## About the application

Application number: 2023/90349	
What is the application for?:	Erection of detached dwelling
Address of the site or building:	adj, 11, Park View, Cleckheaton, BD19 3AN
Postcode:	BD19 3AN

Proposed:  
Floor Plans  
Elevations

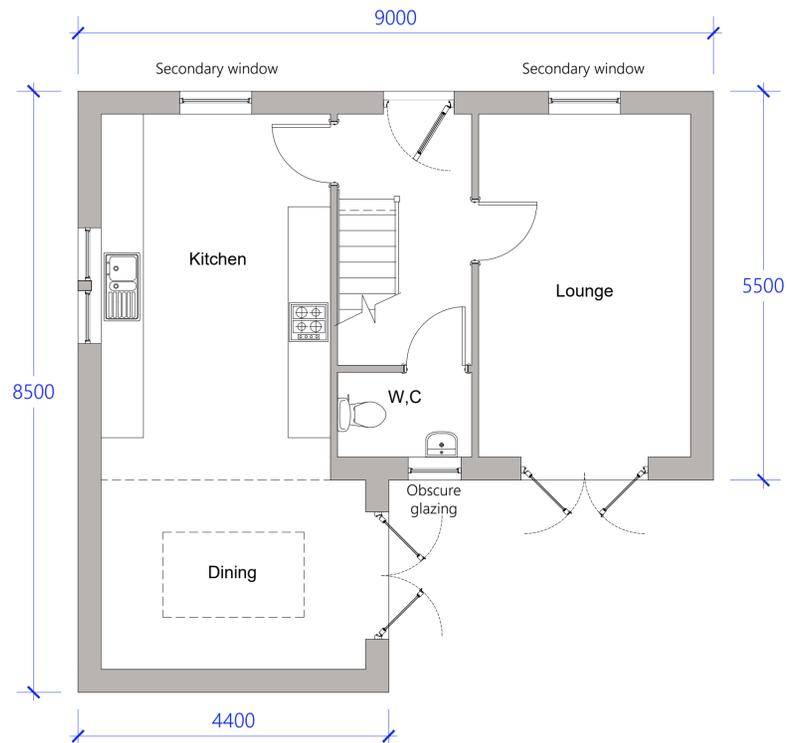
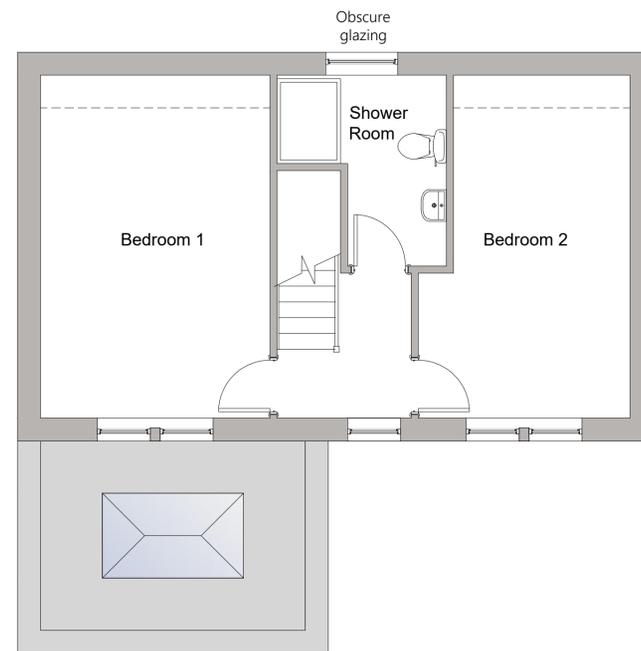
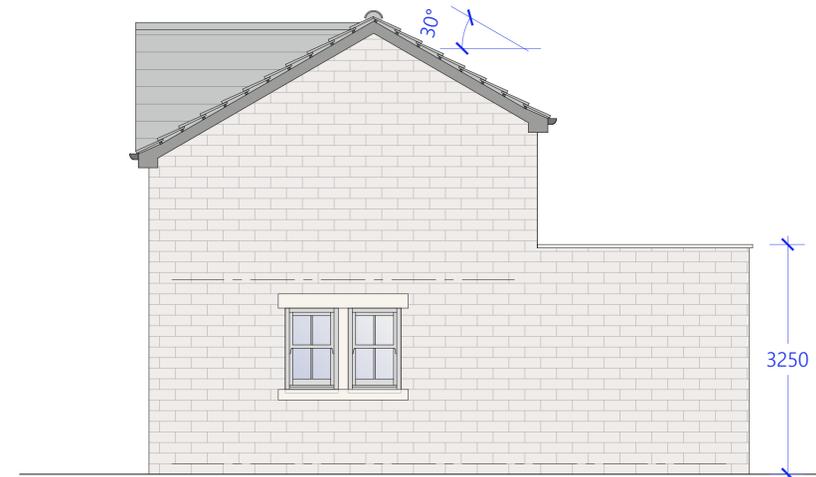
Type of comment: An objection	
Do you wish your comments to be published on the website anonymously?	Yes
<ul style="list-style-type: none"><li>- Building a house in this plot of land will impact on already restrictive parking. Making it more dangerous for pedestrians and children on the school run.</li><li>- A new house will be directly overlooking and overshadowing existing houses and gardens.</li></ul>
